Objection to Planning Application 2026/62/90484/E

Re: Proposed Use of 143 Church Lane, Gomersal, as a 5-Bed Residential Children's Care Home (Use Class C2)

Planning Objection – Professional Concerns Regarding Suitability for Children's Residential Care

Alterations and Extensions to  
143 Church Lane Gomersal, Cleckheaton,  
BD19 4QN.

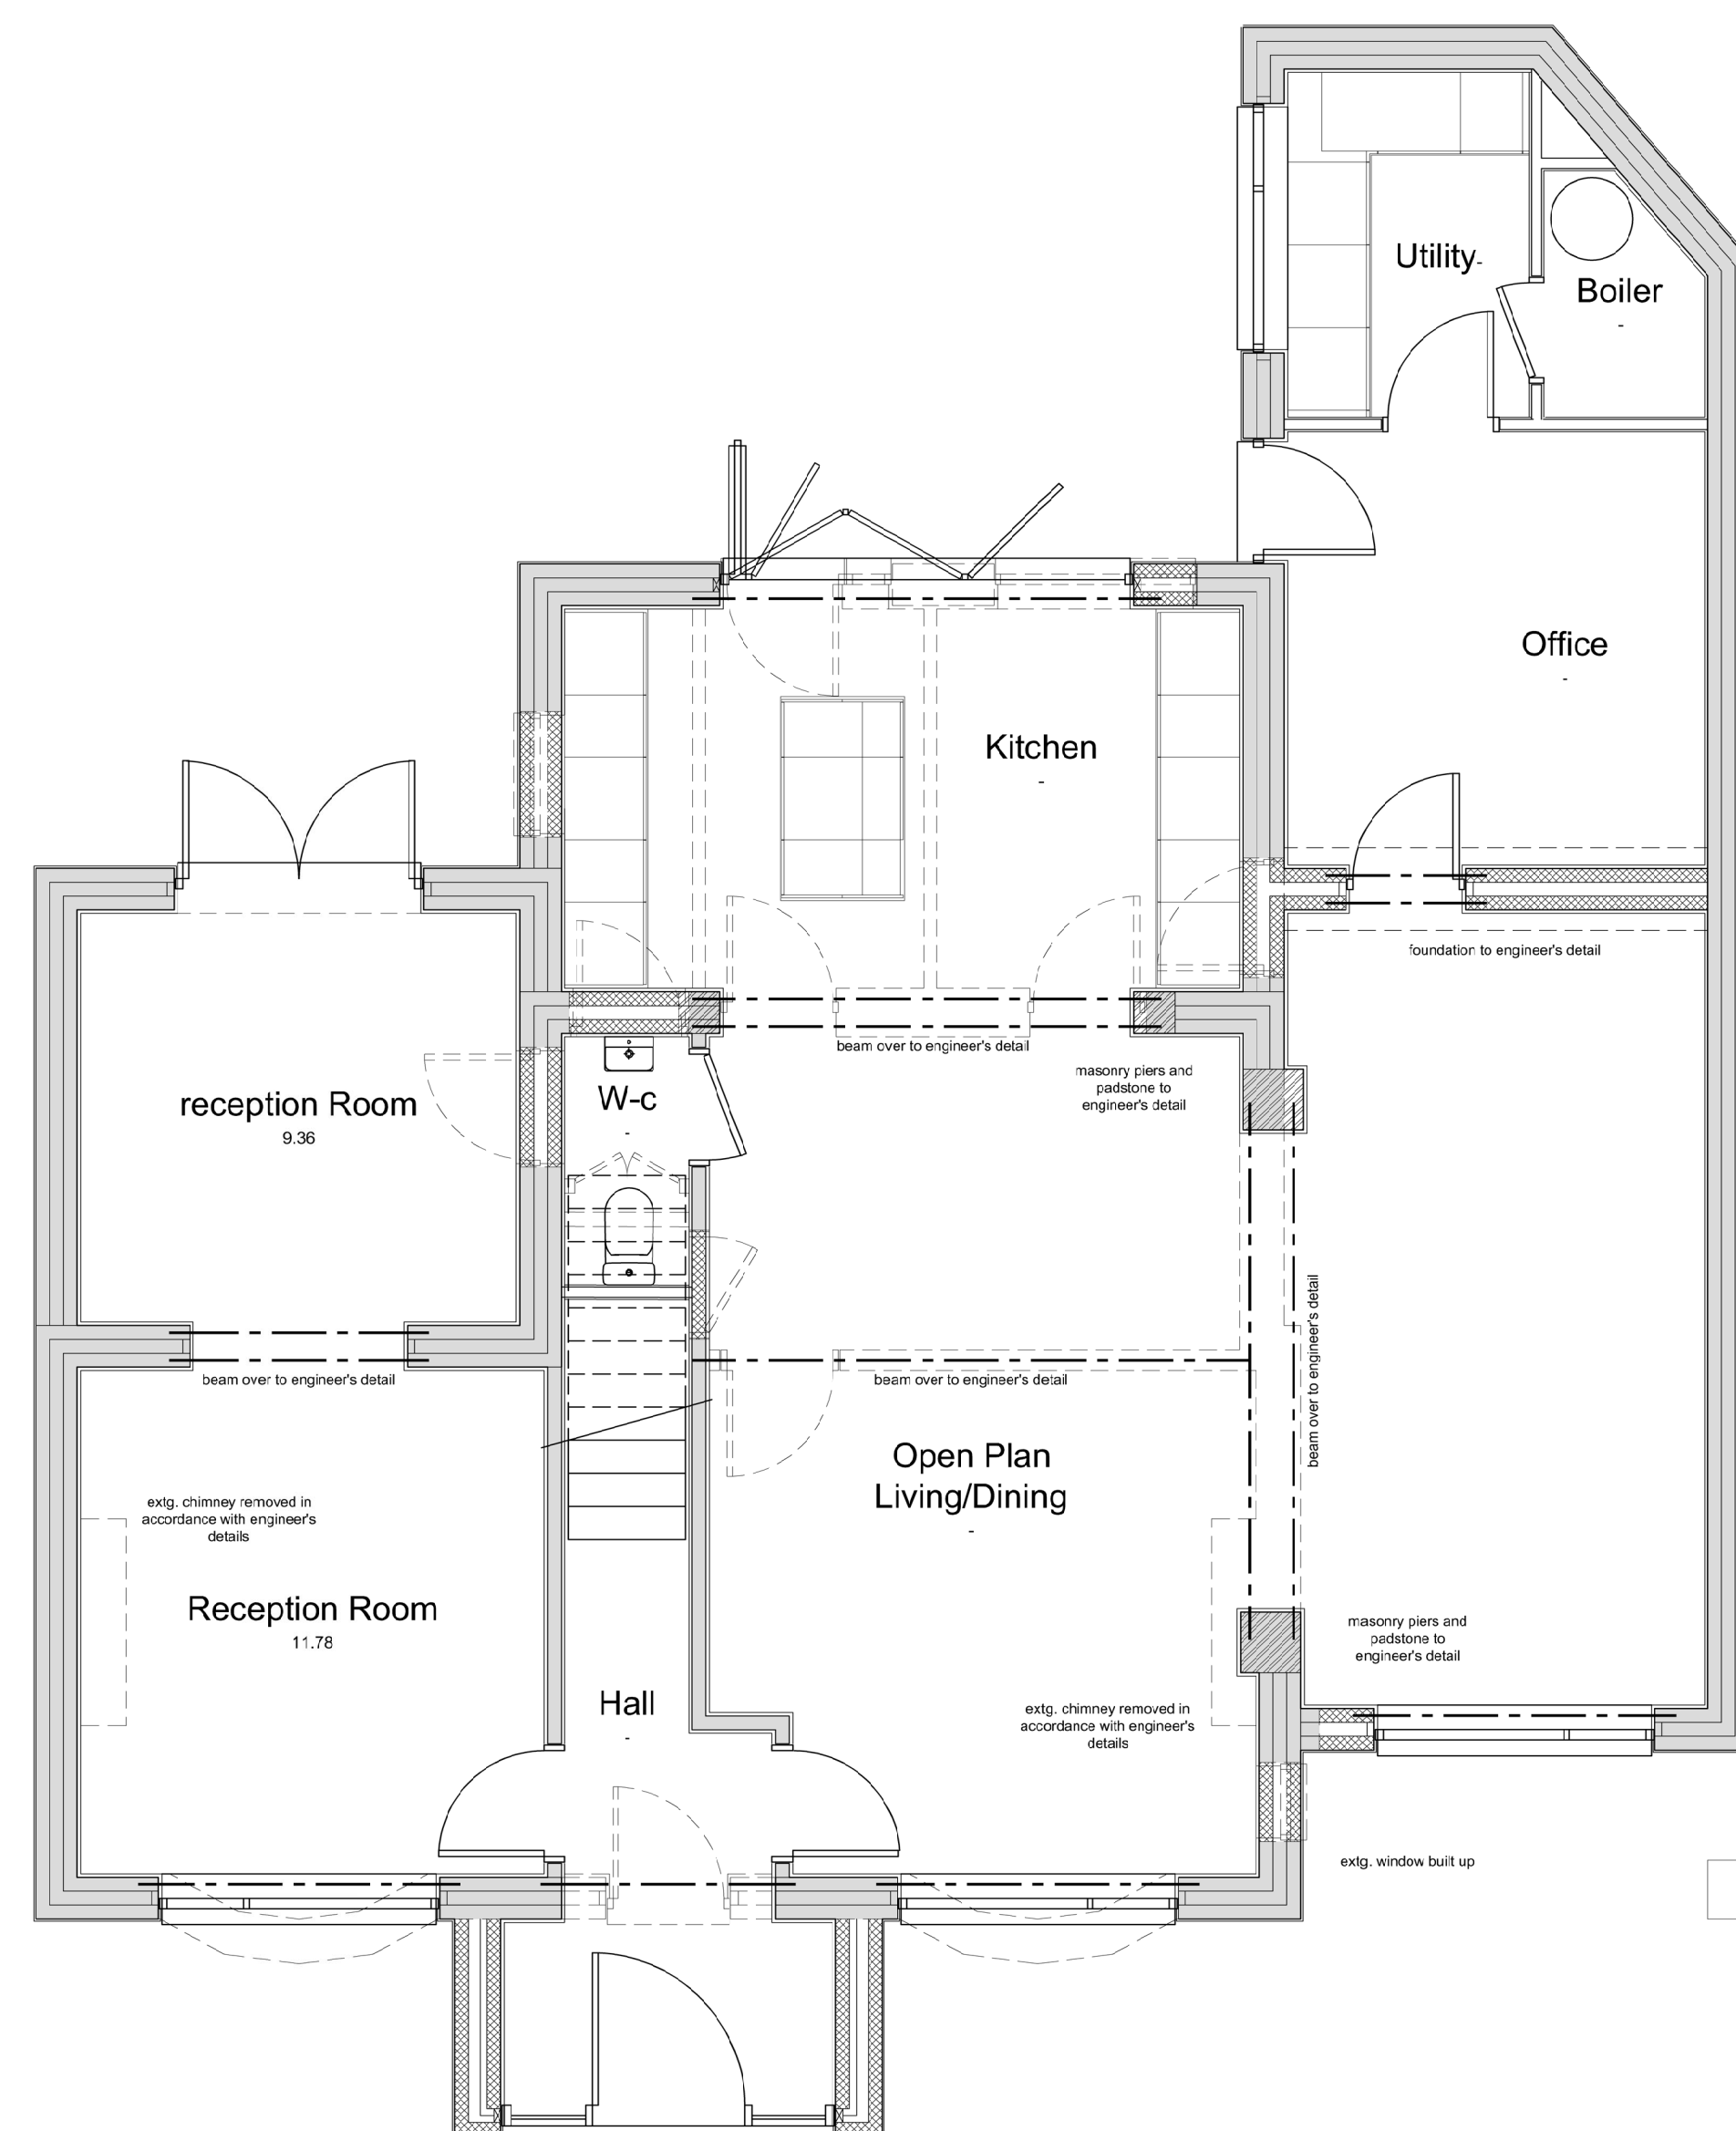
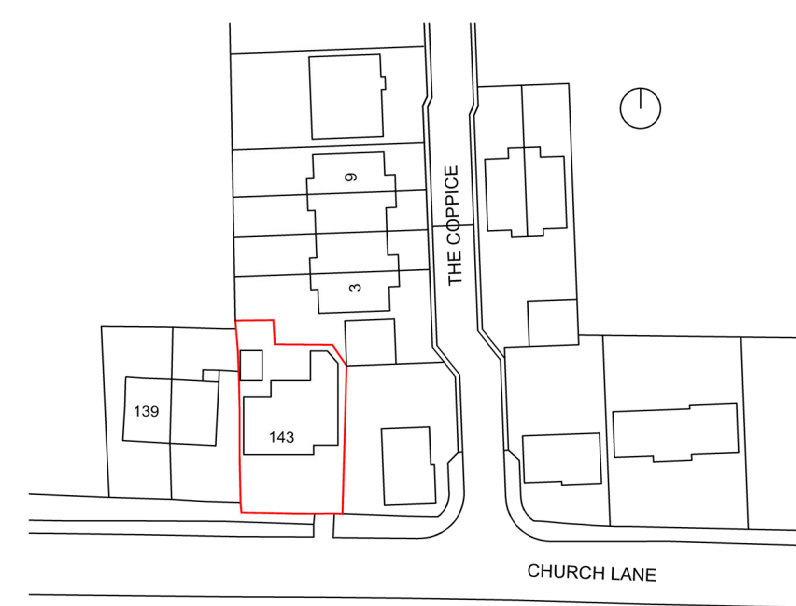
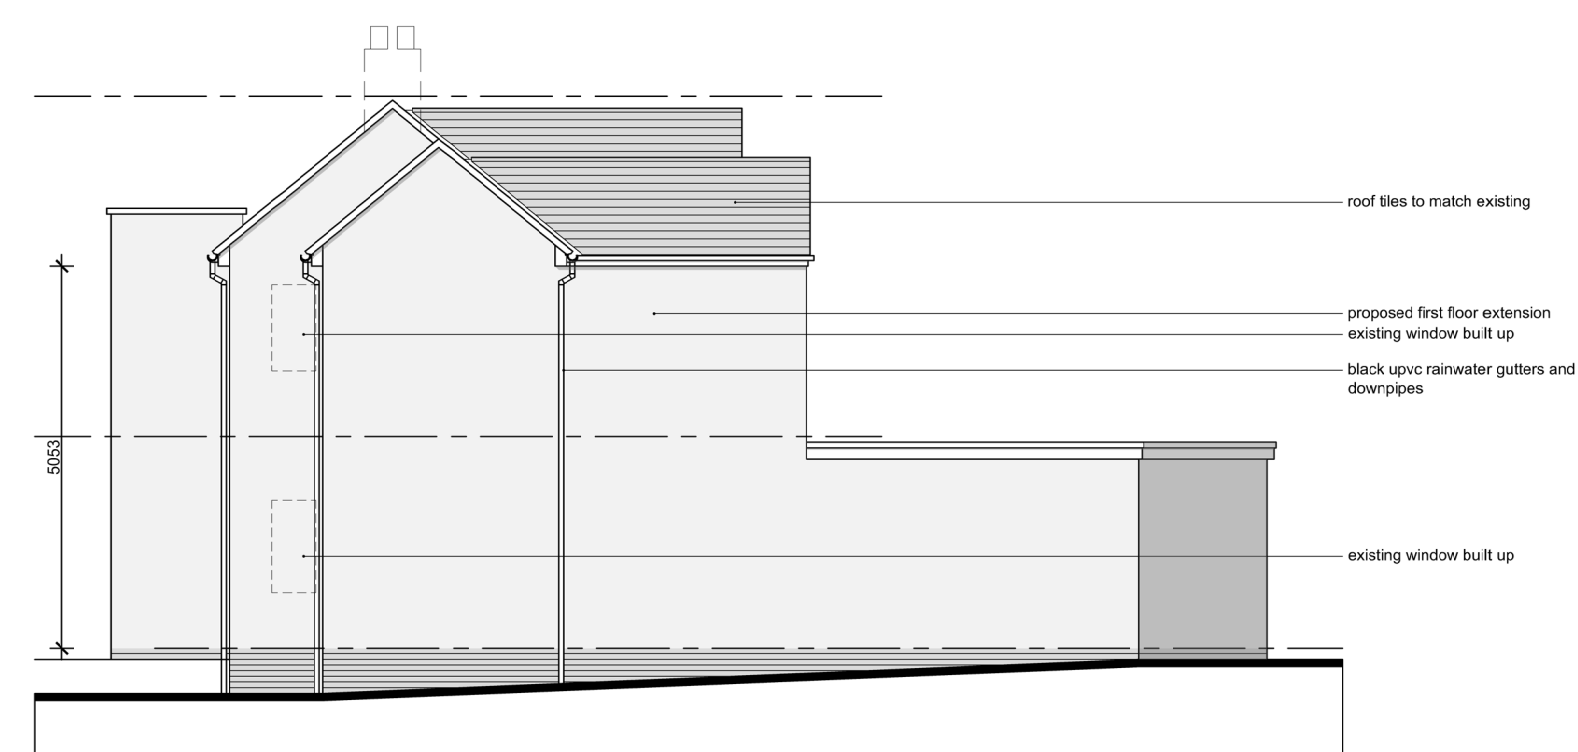
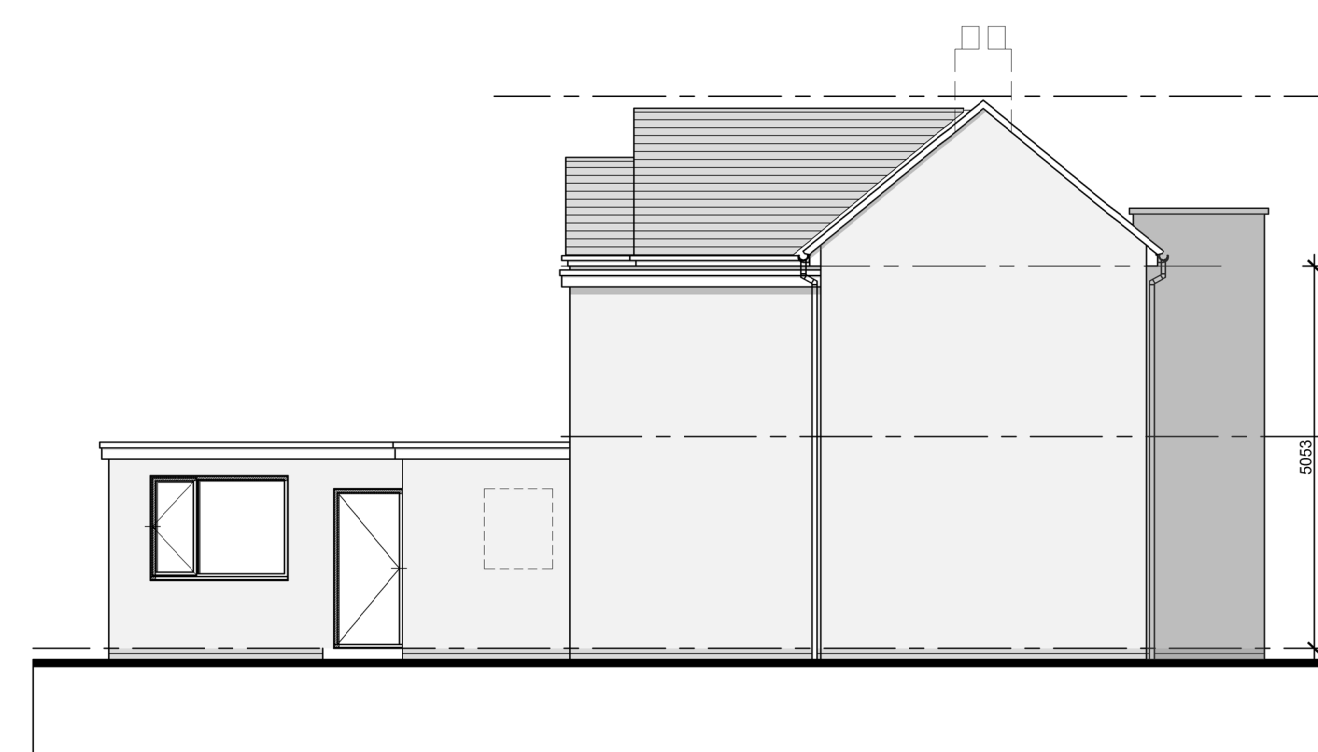
- **Outdoor space is extremely limited**, offering no safe area for regulation, therapeutic activity, or supervised play.
- The **rear elevation directly overlooks neighbouring homes**, intensifying the impact of an already constrained plot and creating privacy issues for both residents and neighbours.

The layout raises serious concerns regarding fire safety and the ability to maintain a secure environment.

- Proposed fire exits appear to lead onto a **flat roof**, creating an unsafe and easily accessible absconsion route.
- **Low boundaries** and proximity to neighbouring gardens reduce the ability to maintain a safe perimeter.
- A **bus stop directly opposite** the property provides rapid access to Leeds and Bradford, increasing absconsion risk before staff can intervene.
- Adjacent farmland contains **livestock and heavy machinery**, posing further risks should a child abscond.
